From: Jean Hunter [REDACTED]
Sent: 14 May 2018 13:21
To: Planning.Responses
Subject: Planning Application EP/52/18/PL Scorton

I attach a document with my comments and objections to the proposed redevelopment of Scorton, 9 Lime Tree Close, East Preston.

West Facing Elevation

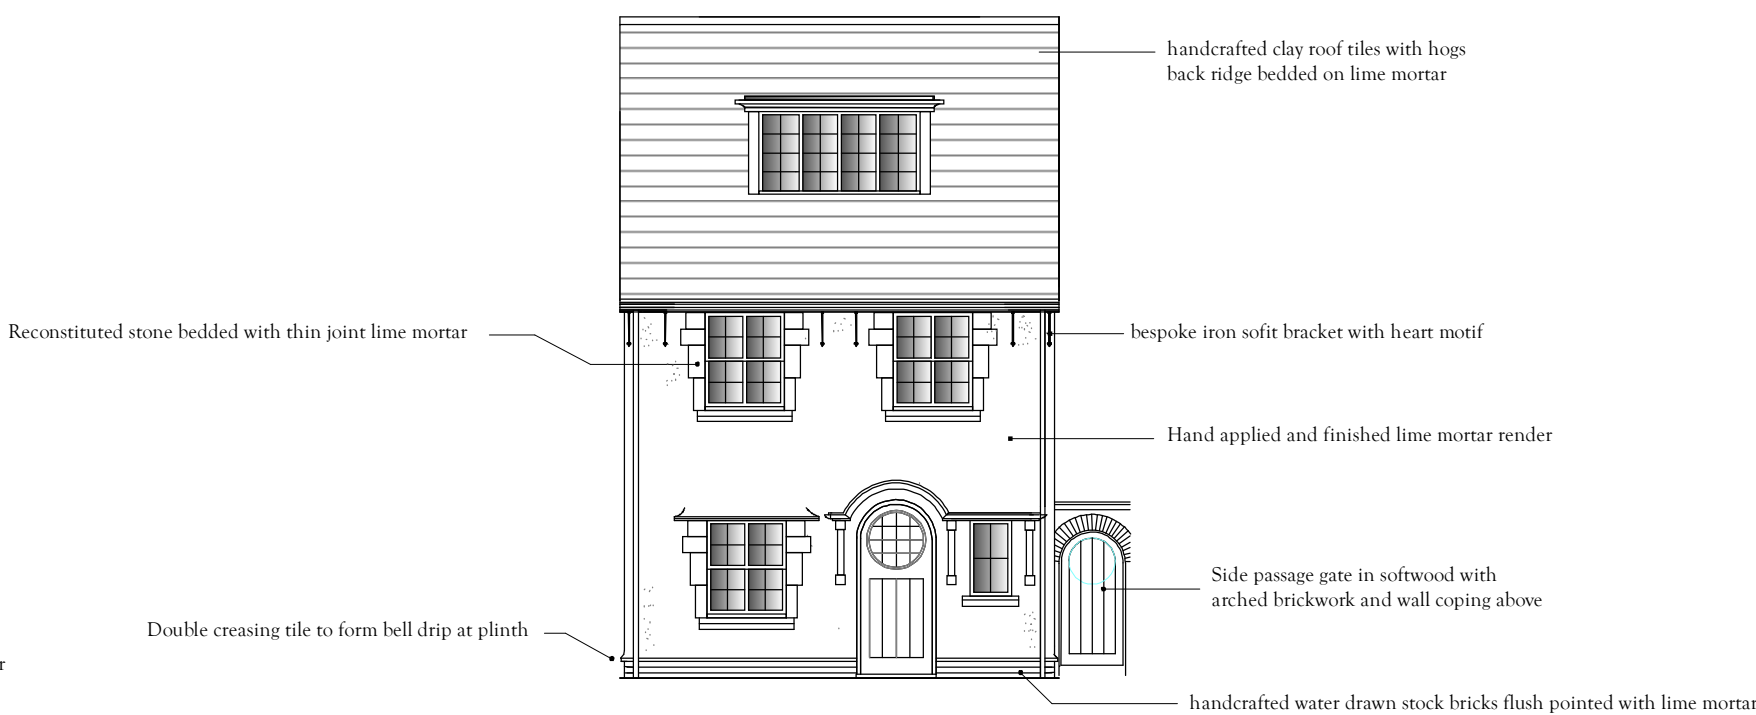
With the proposed development I will lose my very pleasant outlook as plots 4 & 5 will block my view and overlook me.

Plots 4 & 5 will have east facing windows on the 1st & 2nd floors with views down into my garden, my kitchen/diner and rear bedroom. Plot 4 has an ugly flat roof extension to the south with a study on the 1st floor which has an east facing window looking directly down into my property. In my opinion this ugly extension does nothing to enhance the development and it would be better without it. Should these plans be approved as is, I ask that the developer agrees to plant some tall shrubs, preferable evergreen and small trees in strategic positions on the site so that I am not overlooked by

all these windows. Also that the window of the study is of obscure glass and non-opening and that both these are made planning conditions for the plans to go ahead.
